**OXFORDSHIRE COUNTY COUNCIL'S RESPONSE TO CONSULTATION ON THE  
FOLLOWING DEVELOPMENT PROPOSAL**

**Application no:** 14/01830/REM

**Proposal:** Reserved matter – (Outline application 05/01337/OUT) – Details for the proposed sports changing pavilion adjacent to the sports pitches, including 29 associated car parking spaces and 2 coaches bays.

**Location:** Sport Pavilion land off Bankside Adjacent Longford Park Road, Bodicote

Title  
**Sketch Scheme:  
 Floor Plan, Roof Plan and  
 Elevations**

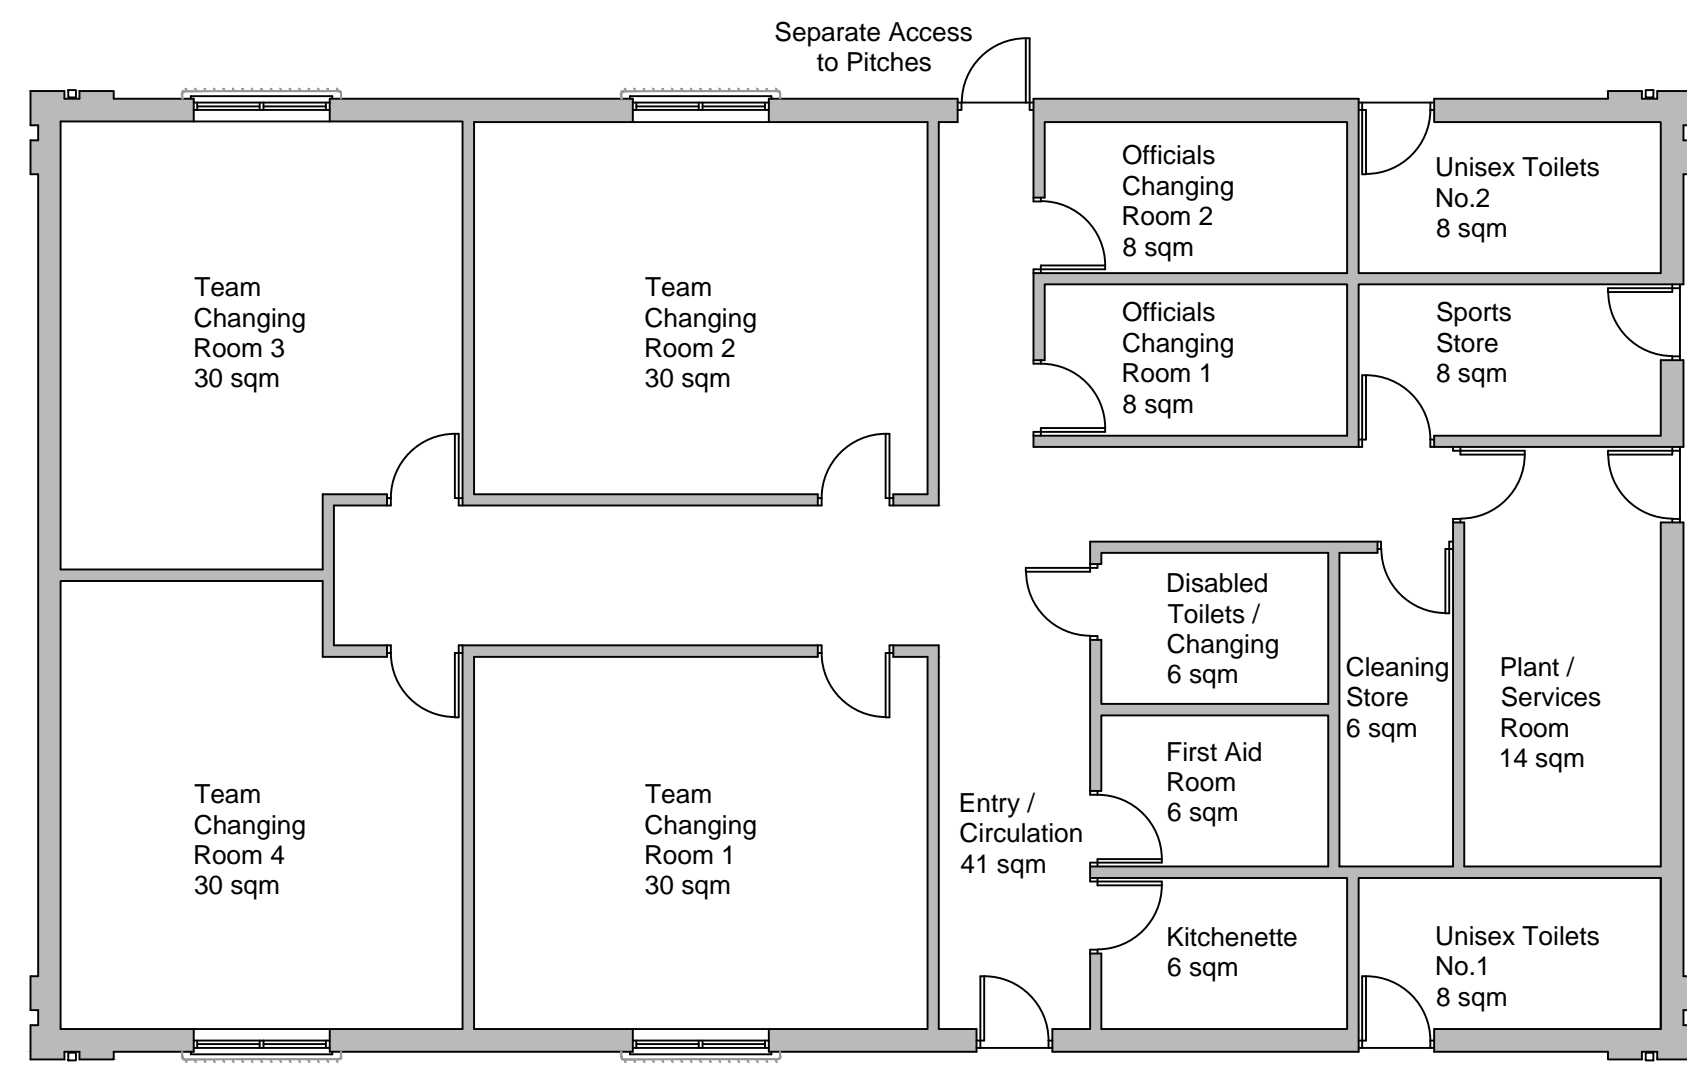
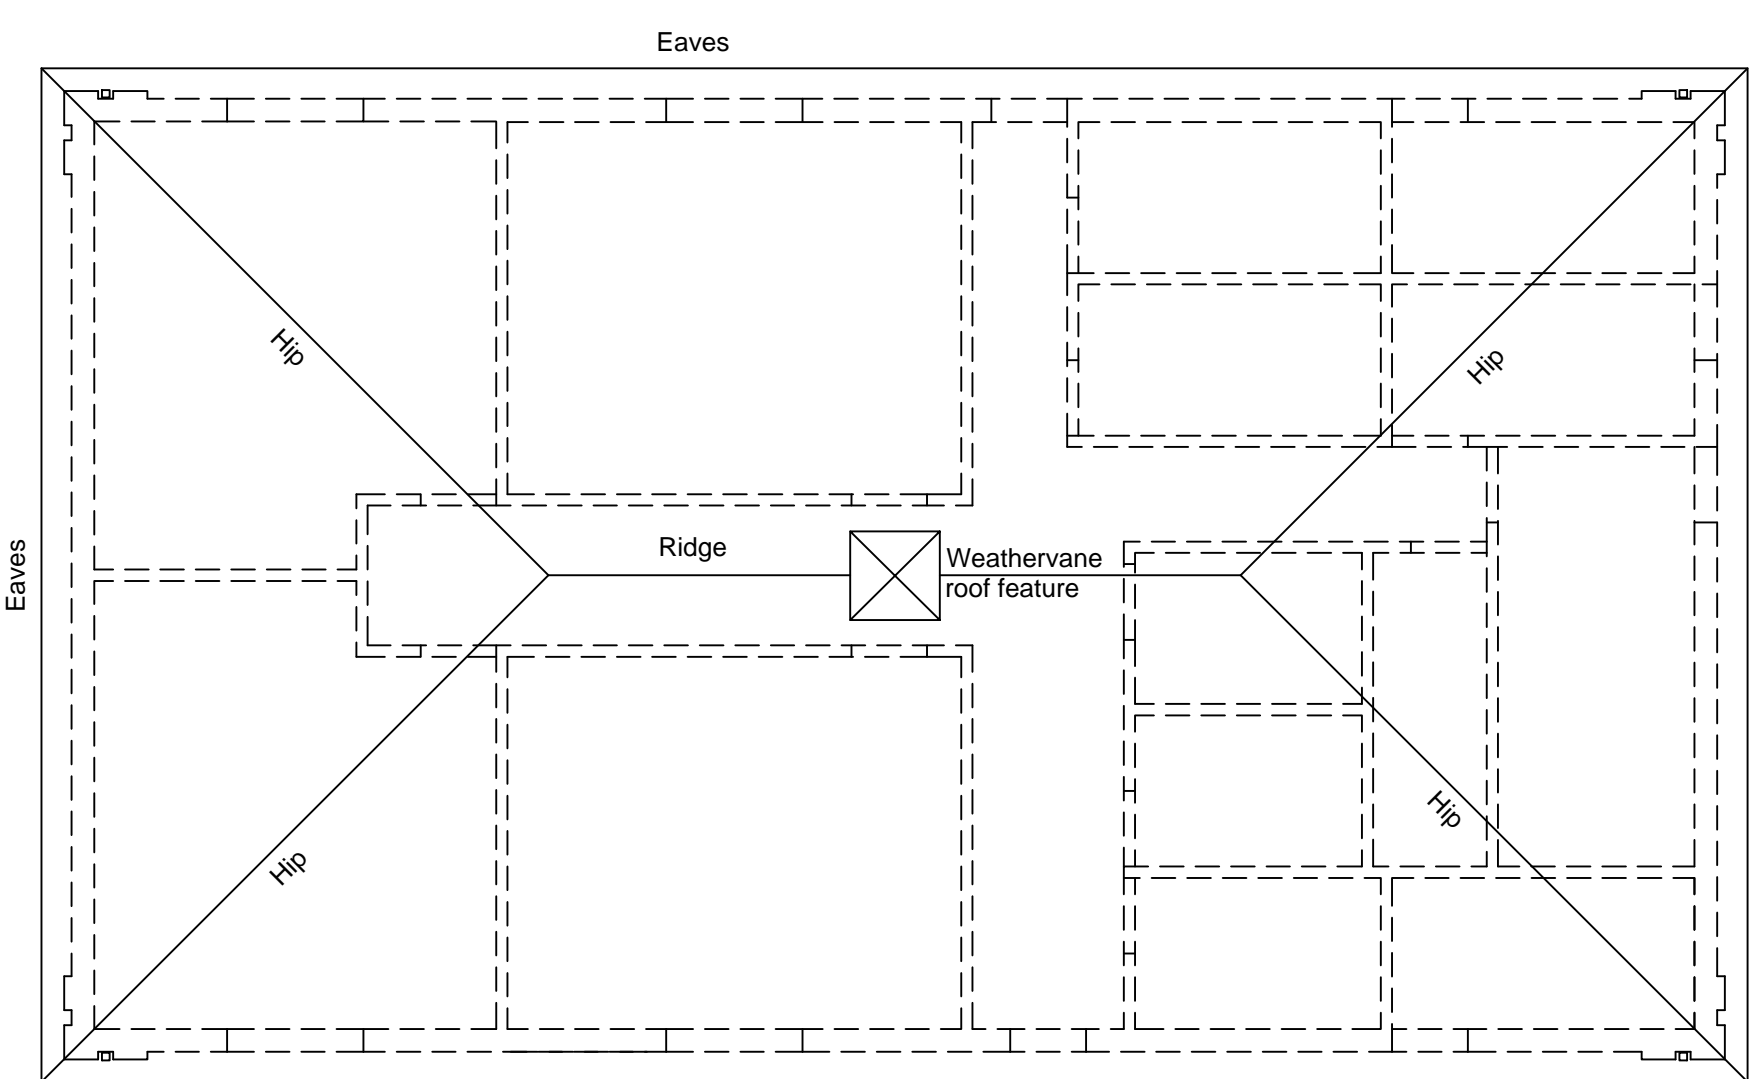
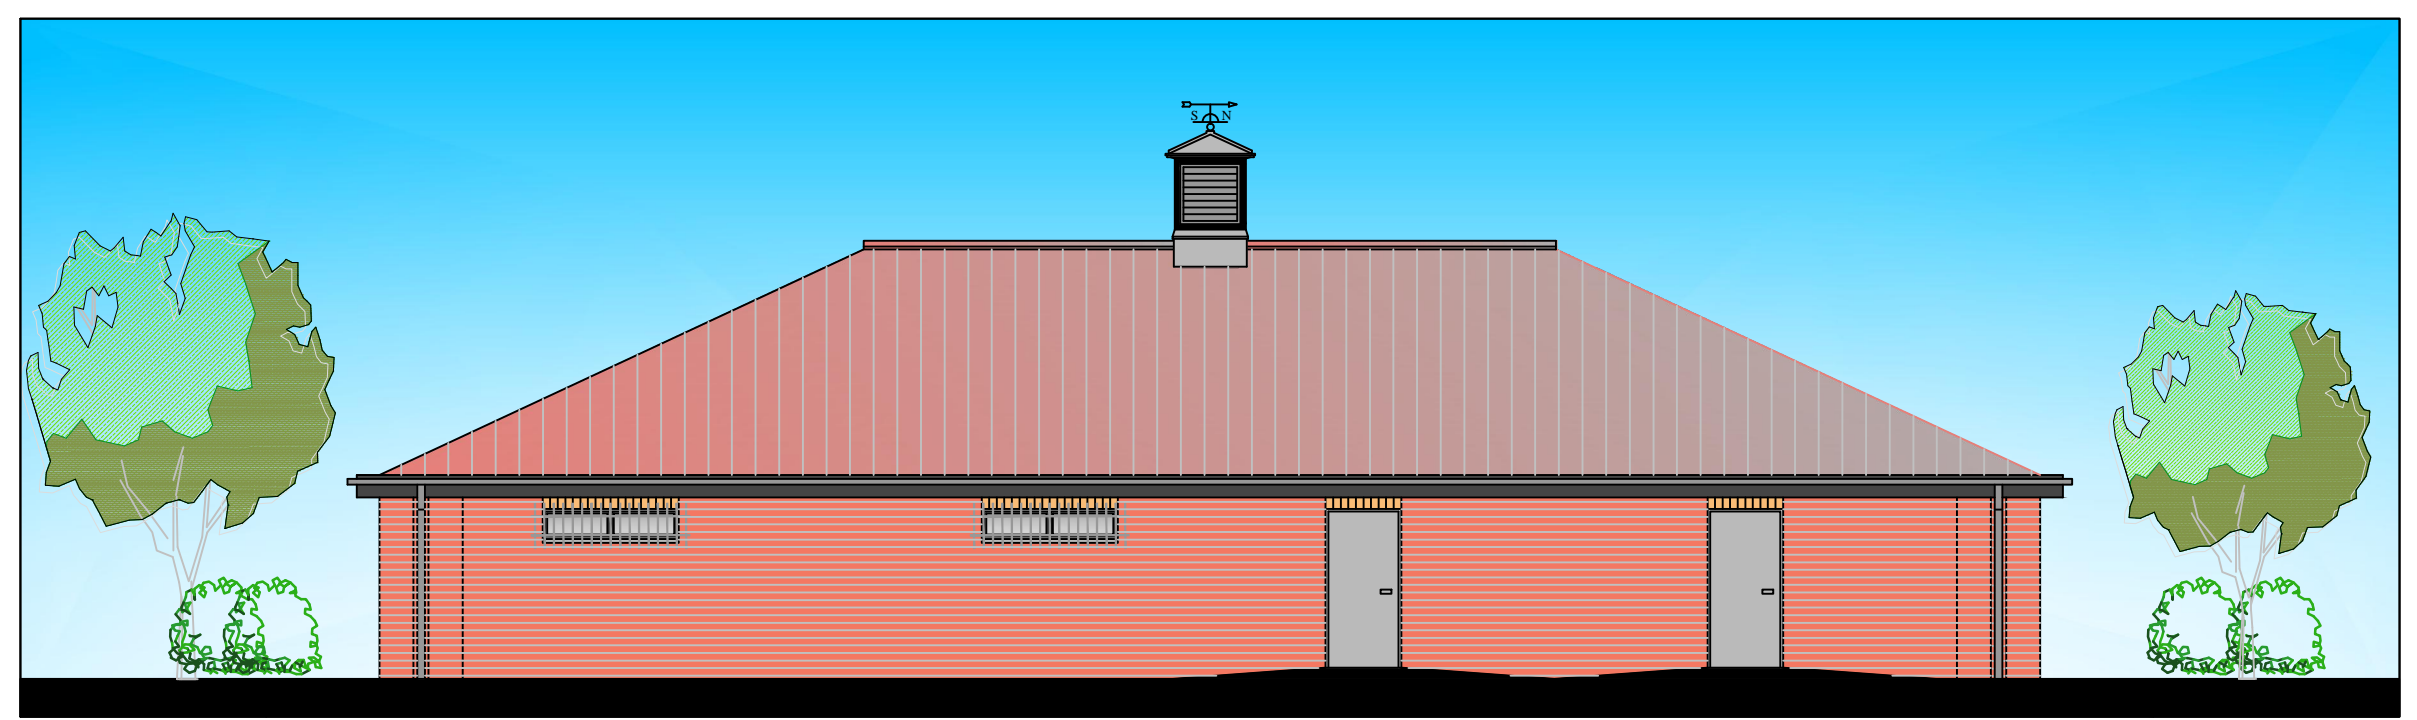
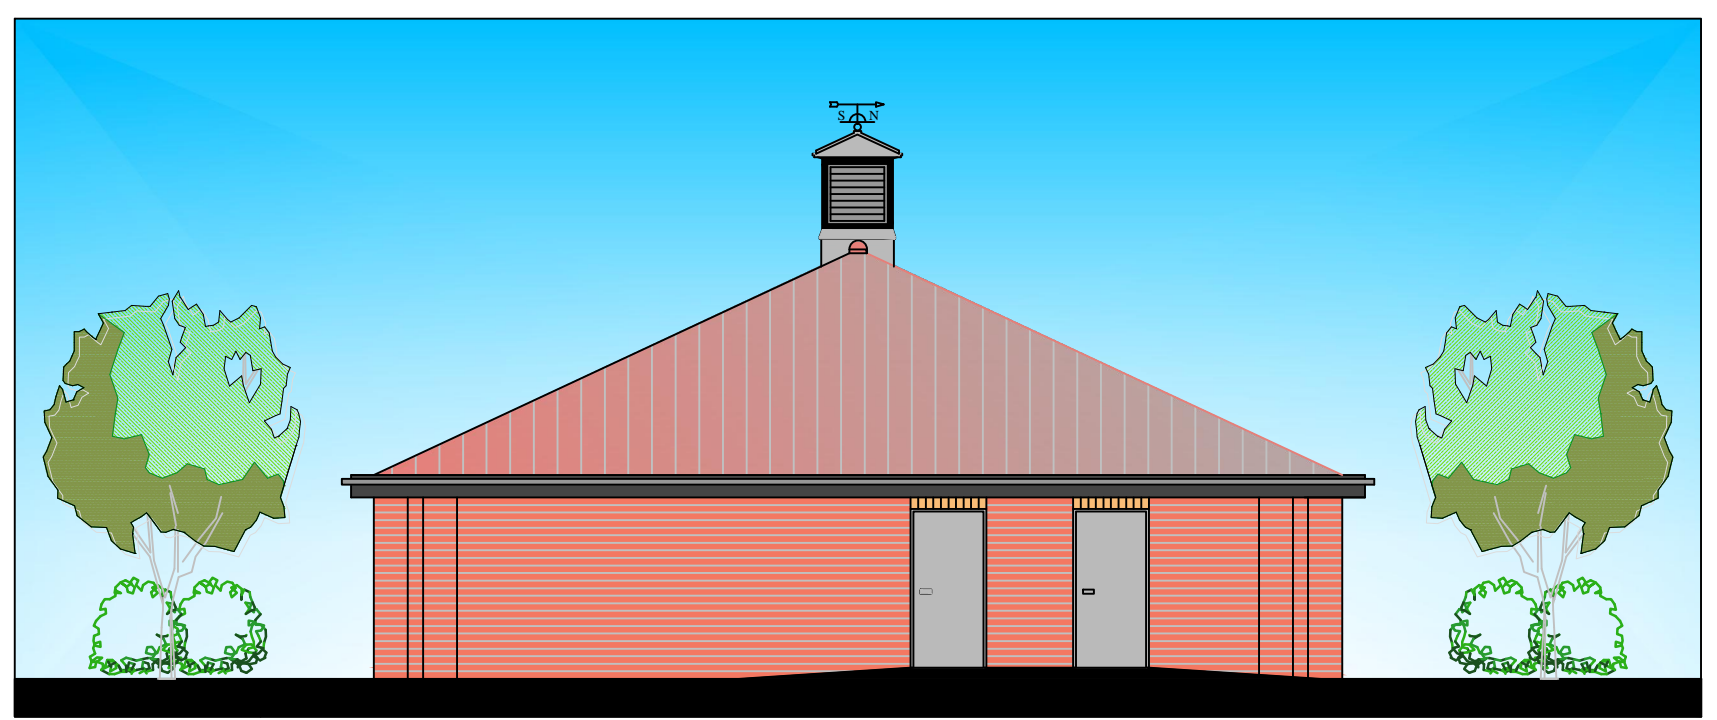
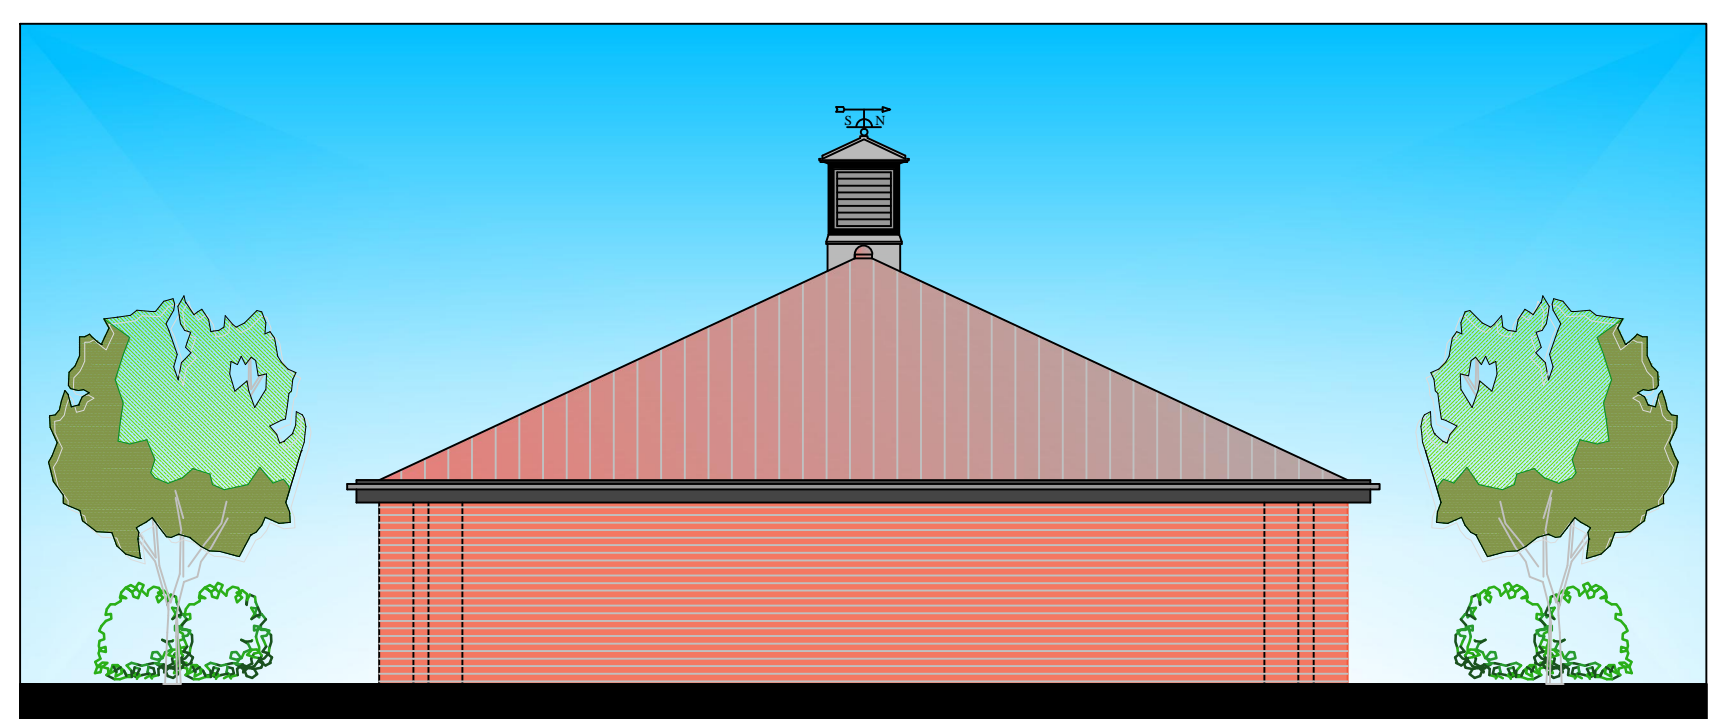
- No Cycle parking has been demonstrated on the supplied plans; this will need to comply with standards in terms of number of spaces, covered/secure, located as close to the main entrance to the building as possible and use 'Sheffield' type cycle stands.
- The Highway Authority has concerns regarding the proposed coach parking arrangement and there is likely access/egress issues – vehicle tracking will need to be supplied
- No refuse storage has been demonstrated, furthermore refuse vehicle tracking will need to be submitted
